COUNTY COUNCIL'S RESPONSE TO CONSULTATION ON THE FOLLOWING DEVELOPMENT PROPOSAL

Application no: 21/02180/REM

Proposal: Reserved matters application for 19/00616/OUT - seeks approval of all reserved matters (excluding access as determined at the outline stage), namely, the layout, appearance, landscaping and scale for the development. Accompanying this reserved matters application submission is information relation to conditions 1, 5, 6, 7, 11, 12, 13 and 17 of 19/00616/OUT

Location: OS Parcel 9507 South Of 26 And Adjoining, Fewcott Road, Fritwell

drawing title
 **Swept Path Analysis**

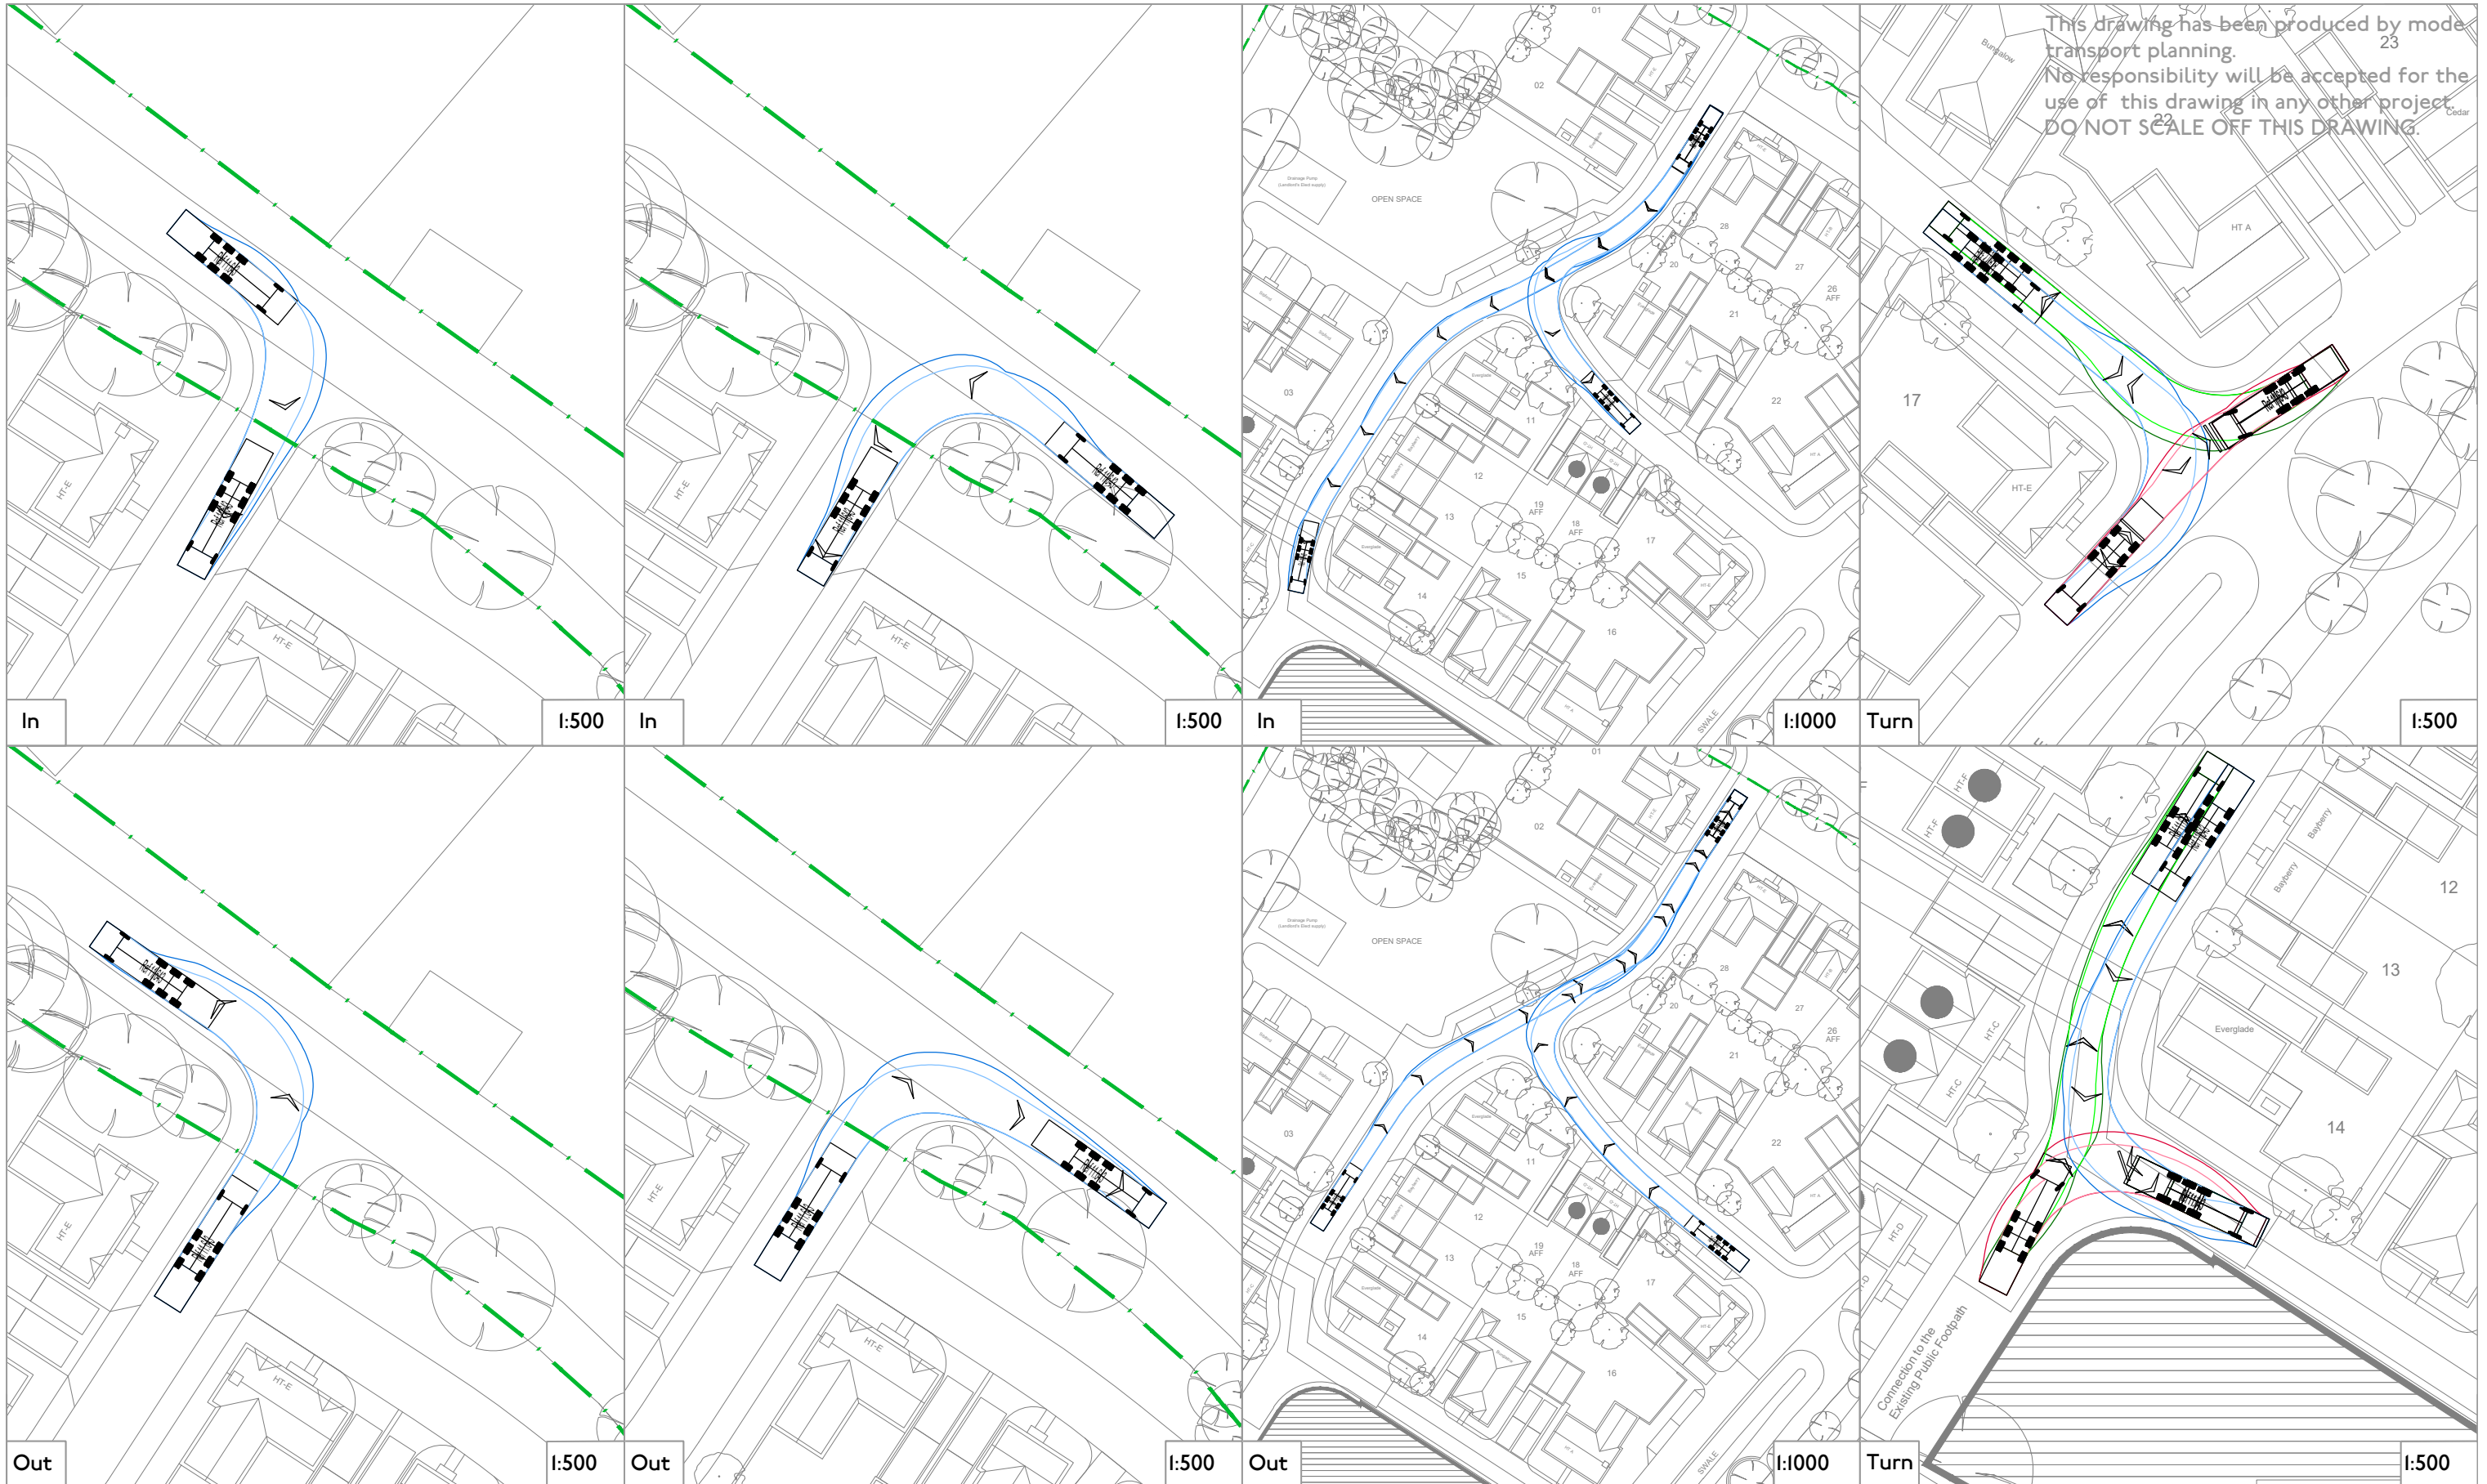
- A swept path analysis for the refuse vehicles accessing the site has been provided, this shows the vehicles which will be the largest accessing the site (11.6m long) needing to use the whole width of the access when turning in/out. Due to low speeds and adequate visibility at this point this is considered acceptable.

The applicant has submitted a swept path analysis for the refuse vehicles using the site (11.6m), this shows the vehicles can safely manoeuvre around the site but require both

lanes when entering/exiting. This is not ideal but as the speeds and traffic will be low and visibility considered adequate, this arrangement is considered acceptable.
